Our Ref: Y/36/20/DOC

**Approval of details reserved by condition imposed under ref Y/72/19/HH relating to Condition No 3 - surface water drainage**

**Rookery Cottage Hoe Lane Flansham PO22 8NT**

Arun District Council have decided to **REFUSE details reserved by condition for the following reasons:**

Surface Water Drainage Strategy

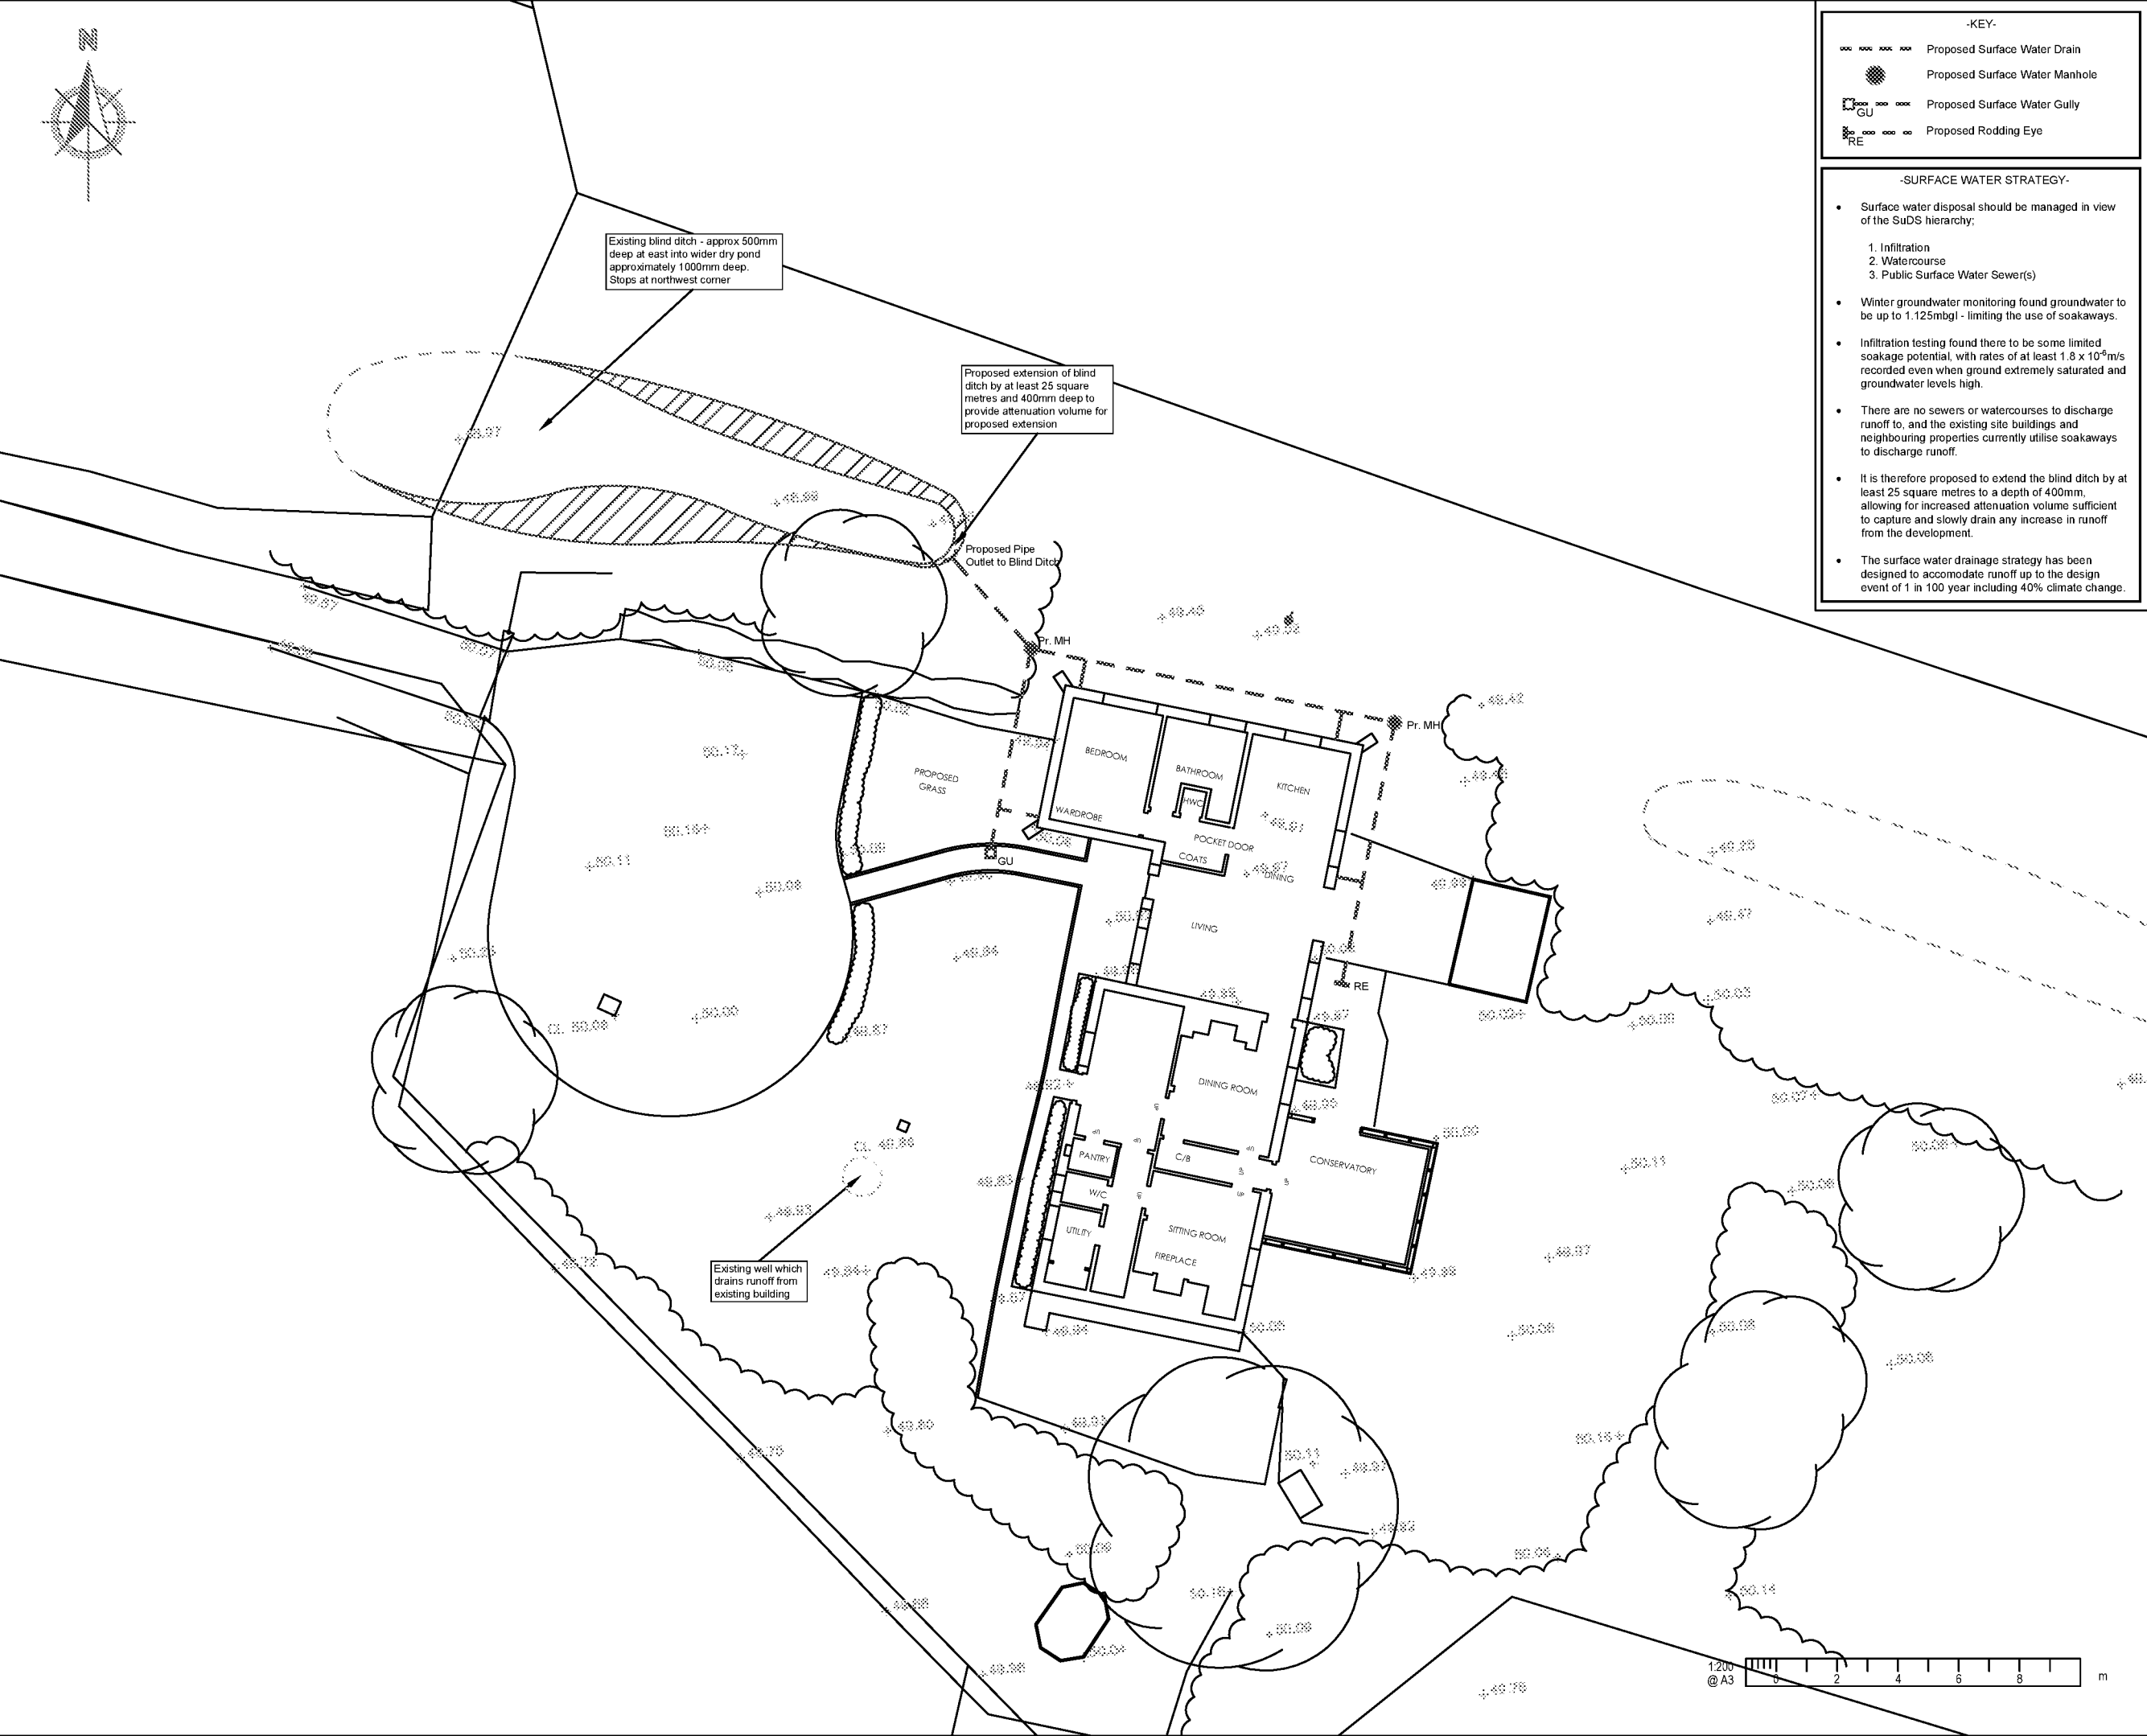
- 1. Apply for and provide proof of Land Drainage Consent.

2. Label surface water pipes with, diameters, pipe materials, falls and invert levels.
3. Label proposed manhole with cover level, invert level, and cover type.
4. Clearly indicate the location of the flow control structure and label this with outflow rate, invert level and design head.
5. Include construction detail drawings for:
  - a. Pipe bed and surround
  - b. Outlet/headwall to the blind ditch
  - c. Control structures/manhole
  - d. Rodding eye
  - e. Gully
6. At least two sections, (cross and longitudinal) of the proposed extension of the blind ditch, these should clearly show the change in capacity. It is likely that two cross sections will be required to do this, one each for the wider and narrower sections of the ditch. These sections should be labelled with invert level, top of bank level, width at the base, and width at the top, side slopes should be a minimum of 1 in 3.
